Engineers Comments Regarding Surface Water Drainage

Application Reference:	F/16/24/RES	Reviewer Reference:	ADC/SB
Planning Officer:	Jessica Riches	Date of Review:	06/01/2025
Site Name:	Land at Ford Airfield Ford		
Application Description:	Approval of reserved matters following outline permission F/4/20/OUT for phase reserved matters 4 (south), for the erection of 357 No. residential dwellings plus associated roads, infrastructure, parking, landscaping, open space & play areas and associated works. This application affects a Public Right of Way, may affect the setting of a Listed Building and falls within CIL Zone 1 (Ford strategic site - zero rated).		
Assessment Number:	1 of 1

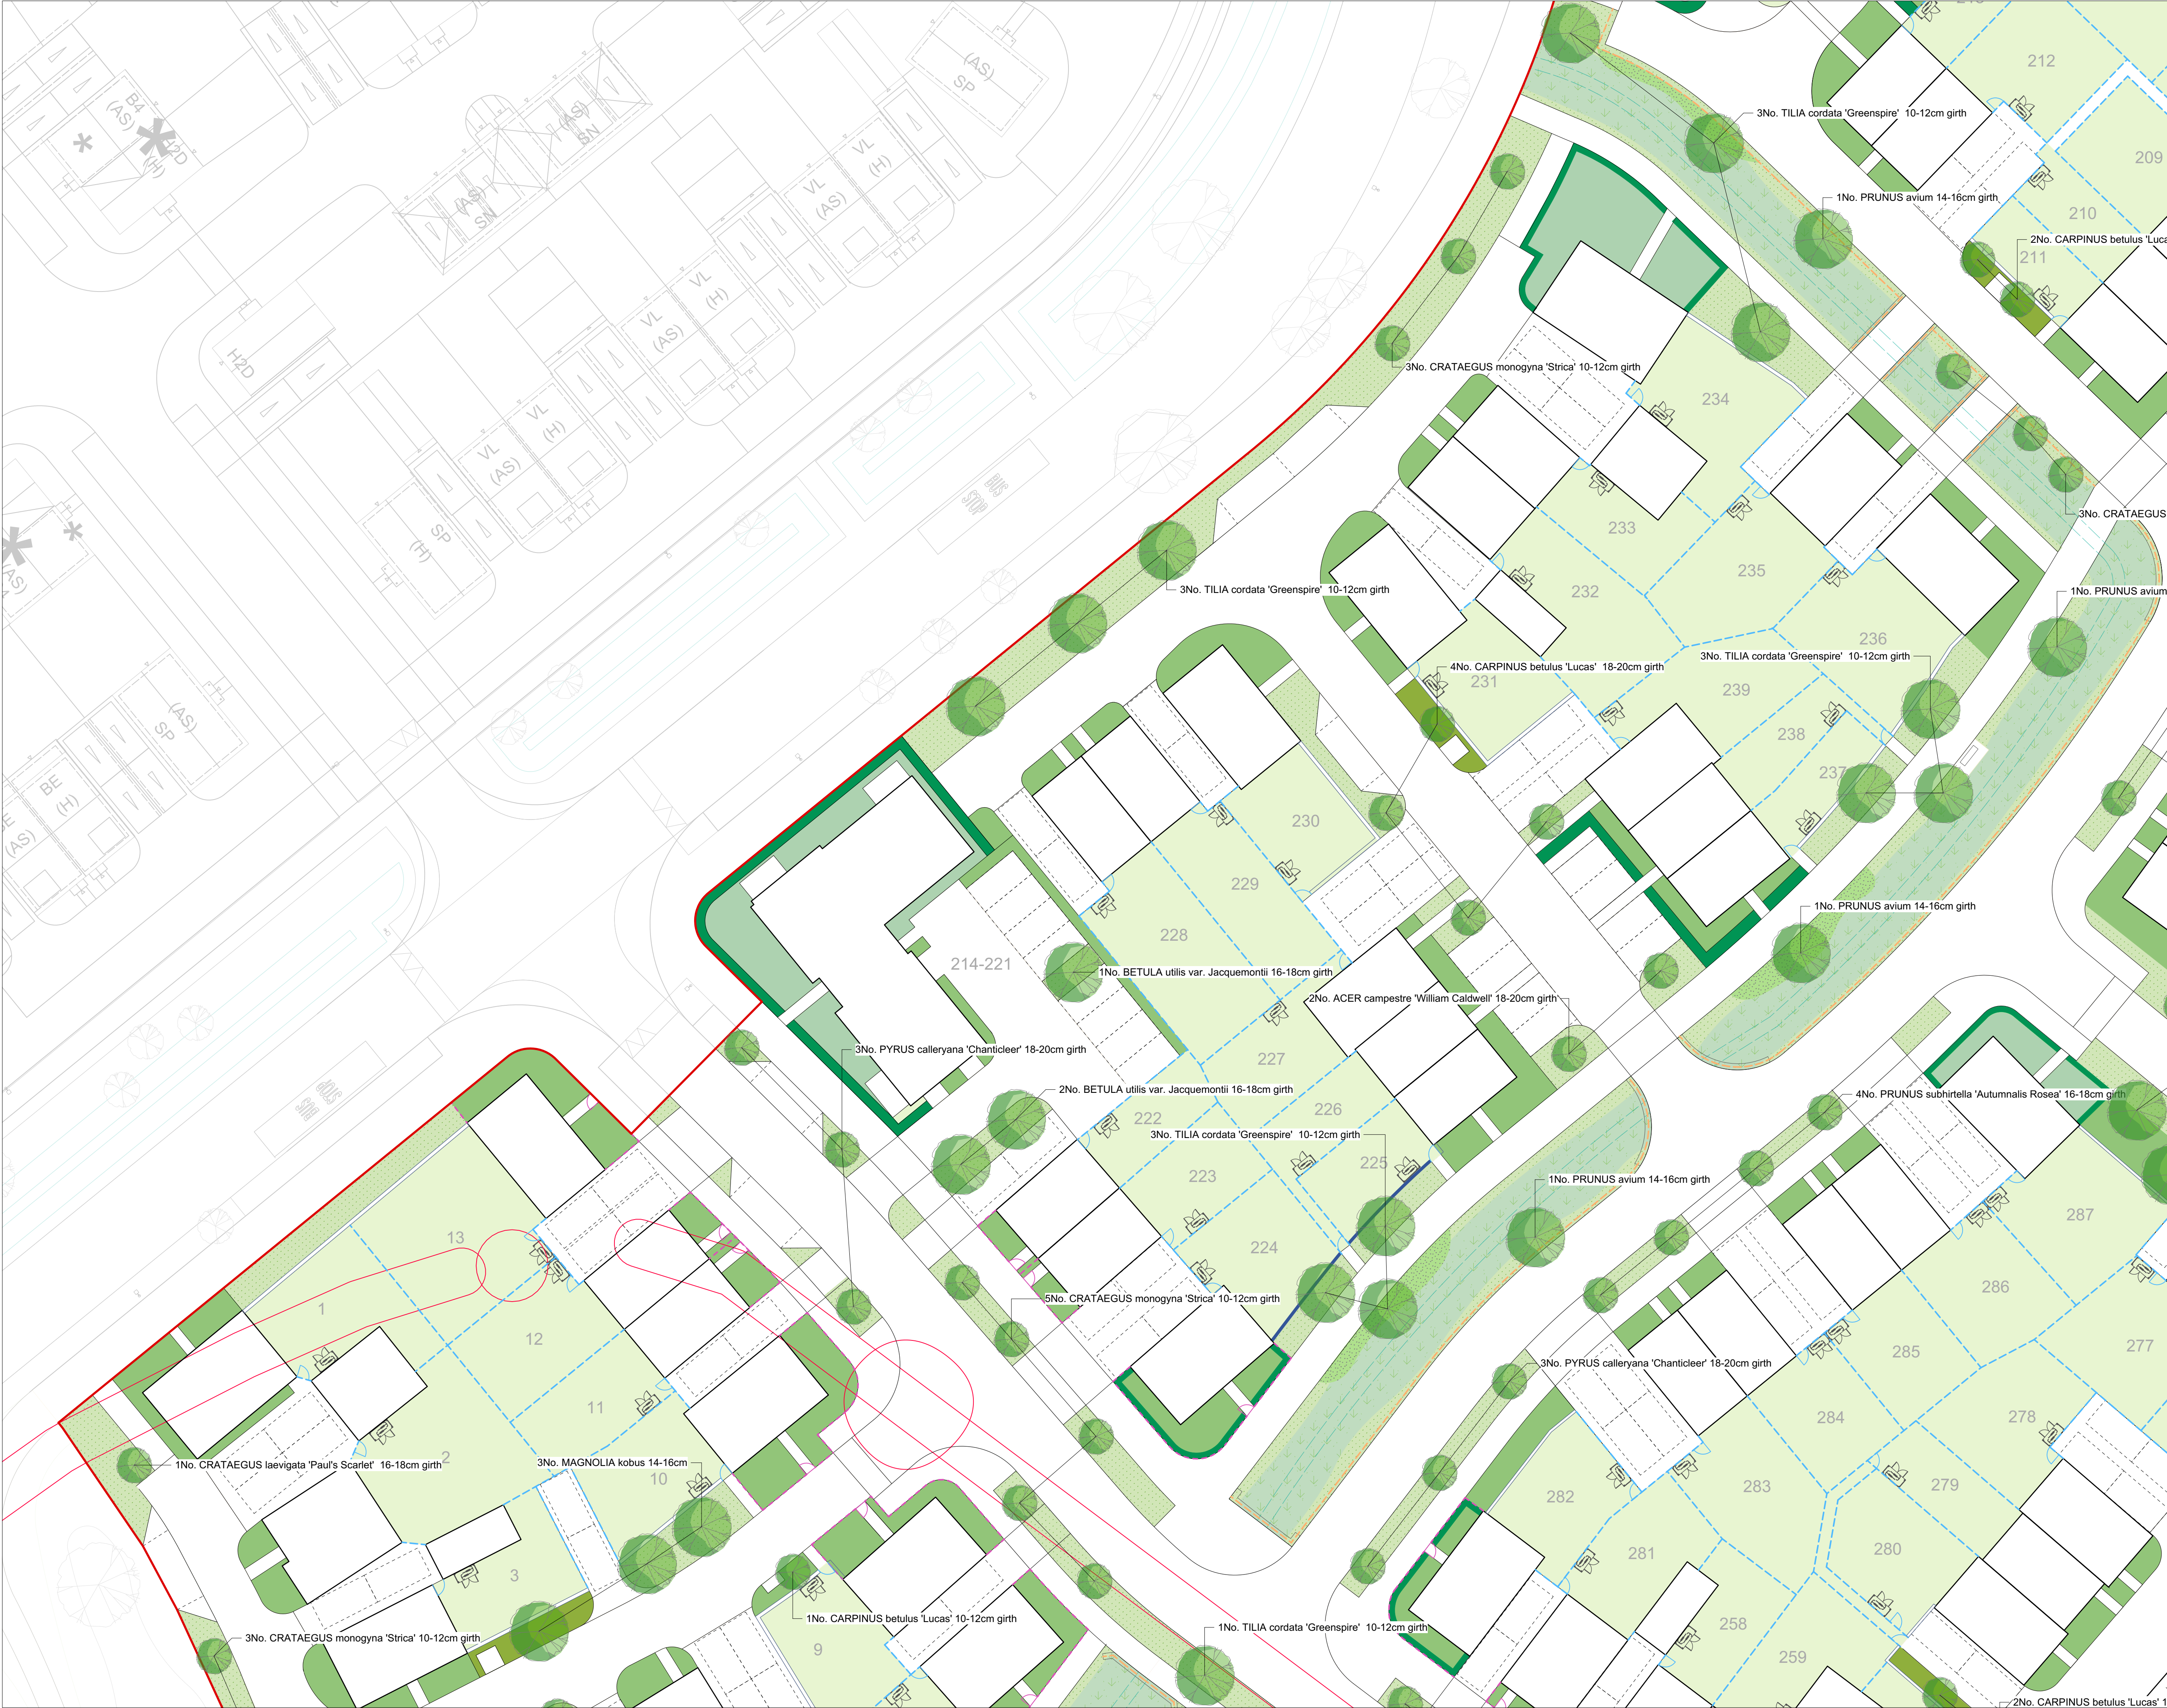
Numerous proposed trees are shown within lined swales. The roots will damage the liners and may allow groundwater ingress. This is not allowed for in the design. If groundwater can enter the system, its volume is unquantifiable and will consume capacity that is reserved for surface water storage. By extension this is likely to increase flood risk. Landscaping is being agreed at this stage and the inclusion of these trees may mean that the swales cannot be agreed or approved later via condition. The swales provide important shallow conveyance, biodiversity and amenity benefits.
